Project Name: SUNPORT MUNICIPAL & ALBUQUERQUE INTERNATIONAL SUNPORT

DRB Comments

RE: Albuquerque International Sunport

**RE: Request for Temporary Deferral of Sidewalk Construction
Project No. 1007630 SDP for Building Permit
City of Albuquerque Aviation Department Land Lease
NMDOT/Aviation Division Office**

TITLE: NMDOT - AVIATION DIVISION OFFICES

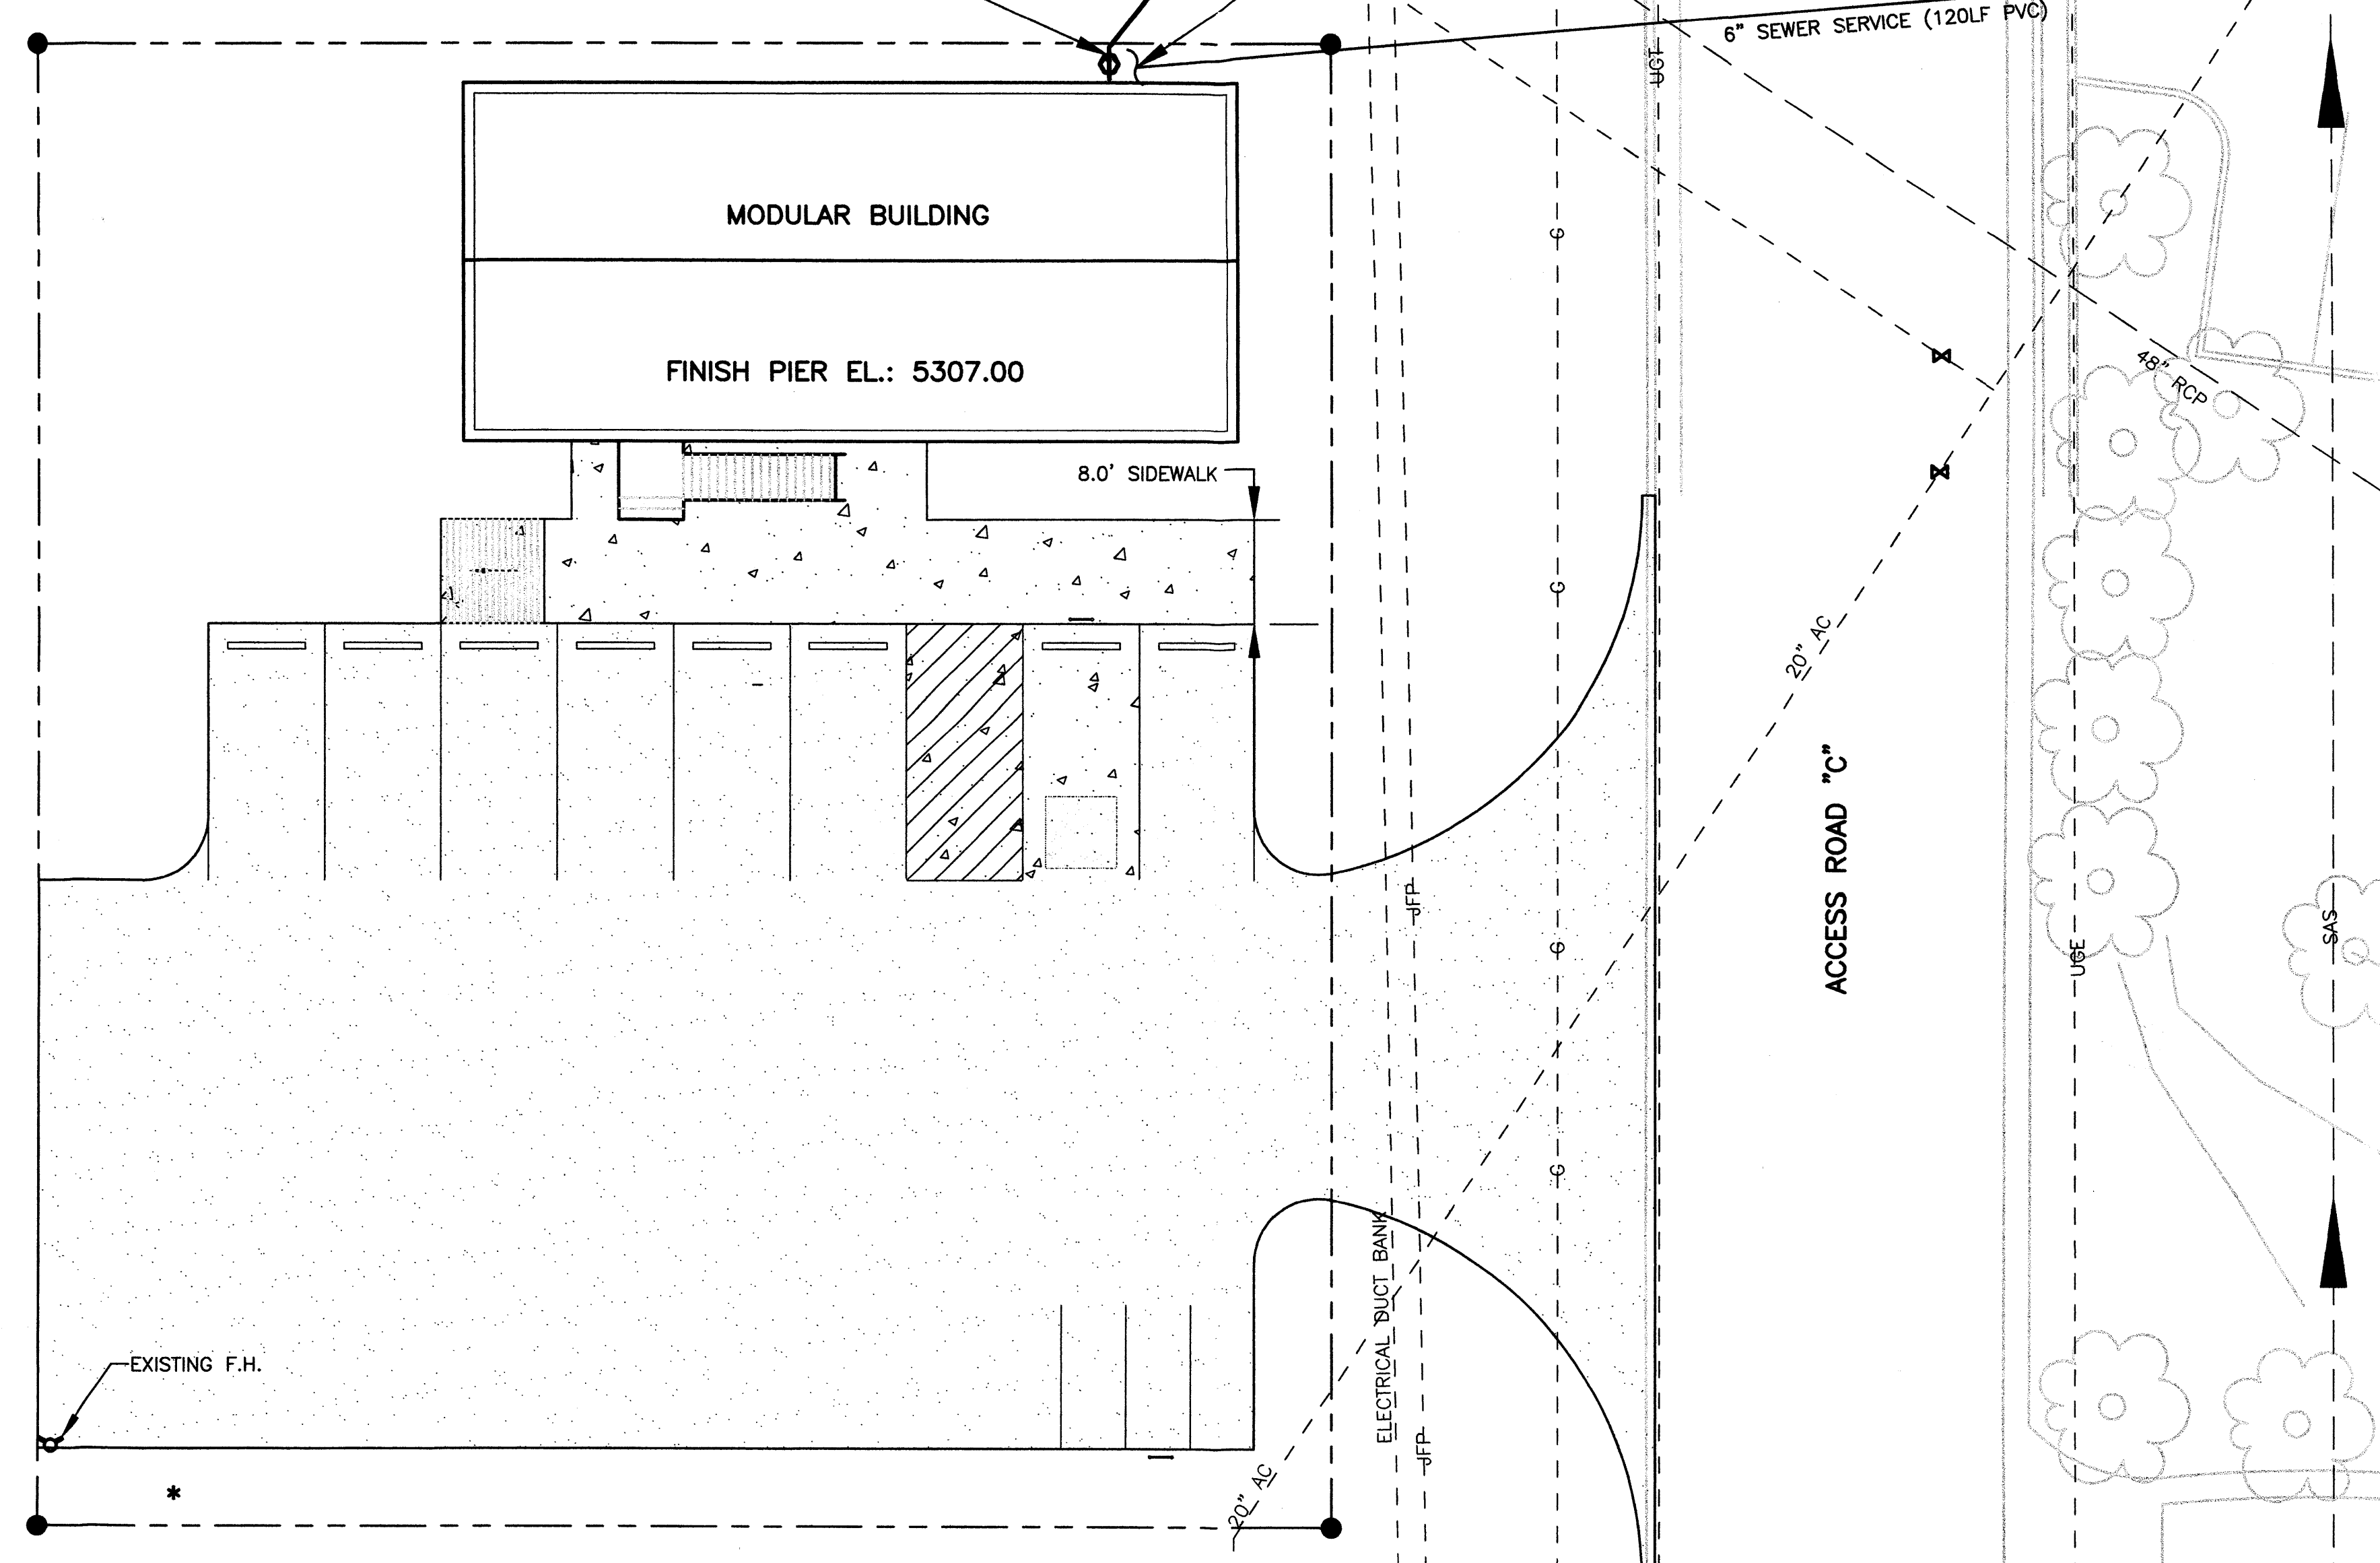
The Traffic Circulation Plan contains much of the information needed for the Site Plan – Sheets C- 101 and C-102 needed to have data combined.

Per Zoning Code, concrete or asphalt entry is needed into parking lot.

Clarification is needed regarding sidewalks; it appears that returns and ramps at parking lot entry need to be constructed with this site plan.

LANDSCAPE PLAN

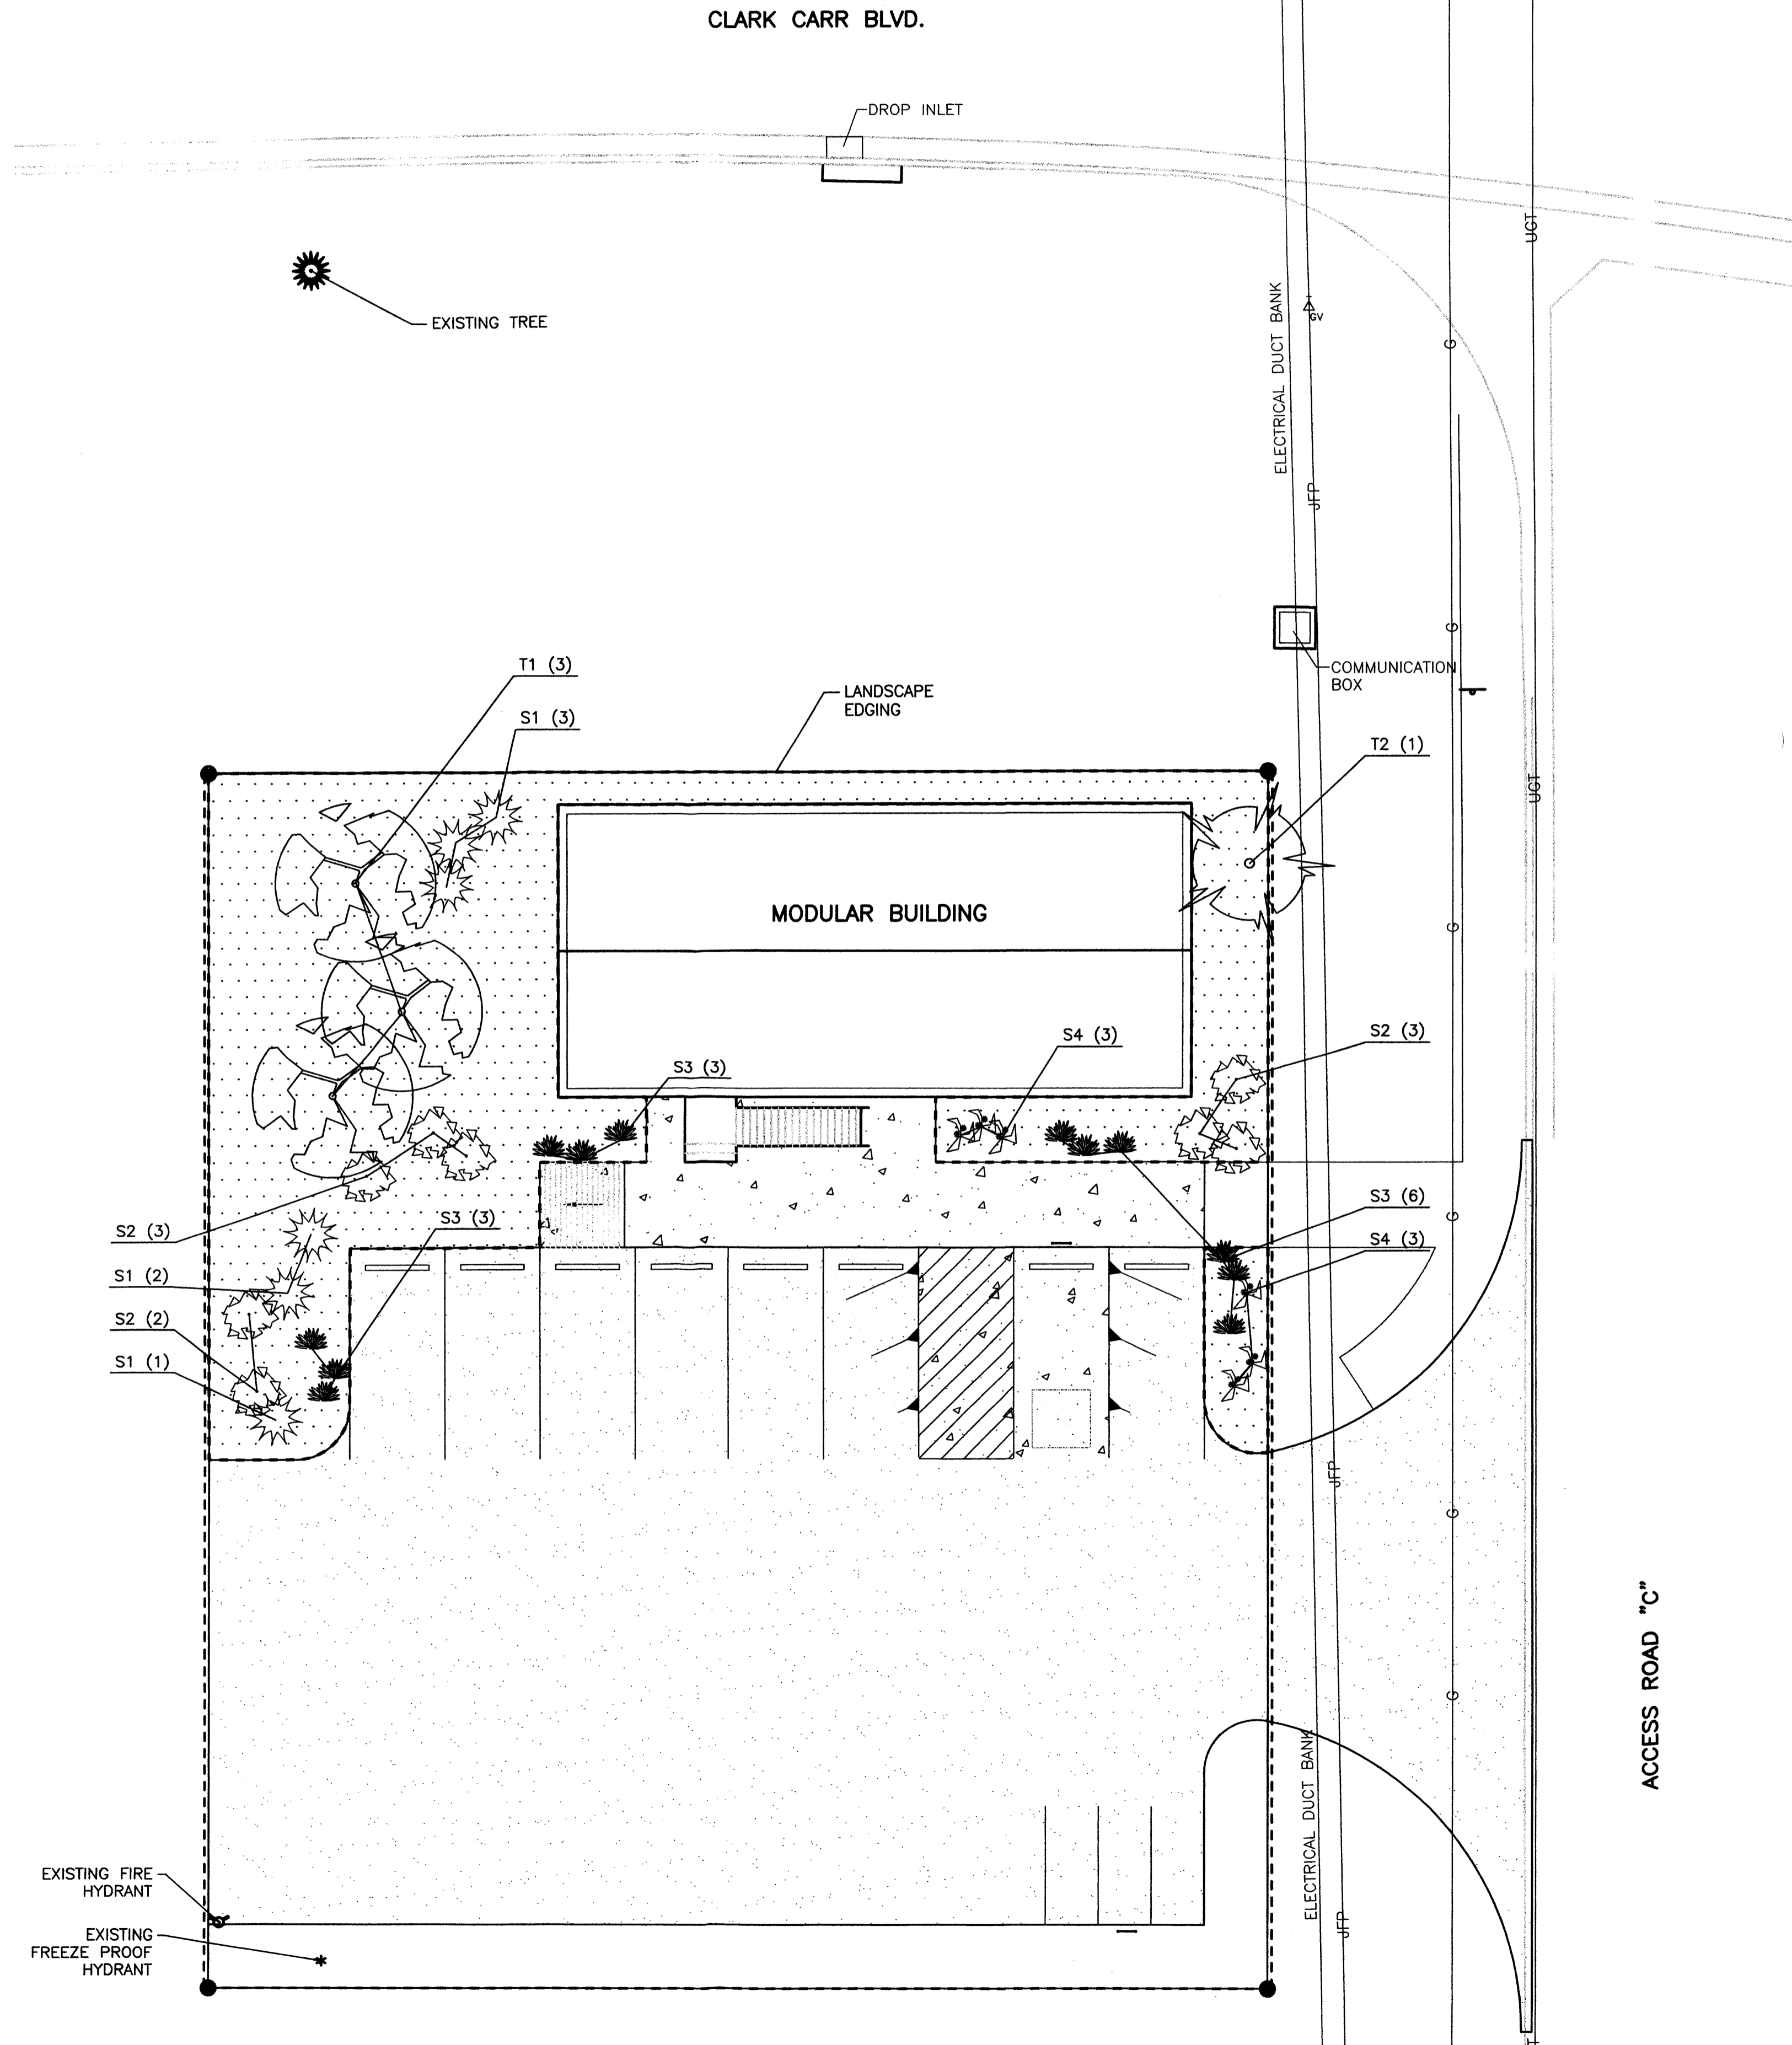
Landscaping needs to be included out to street edge.
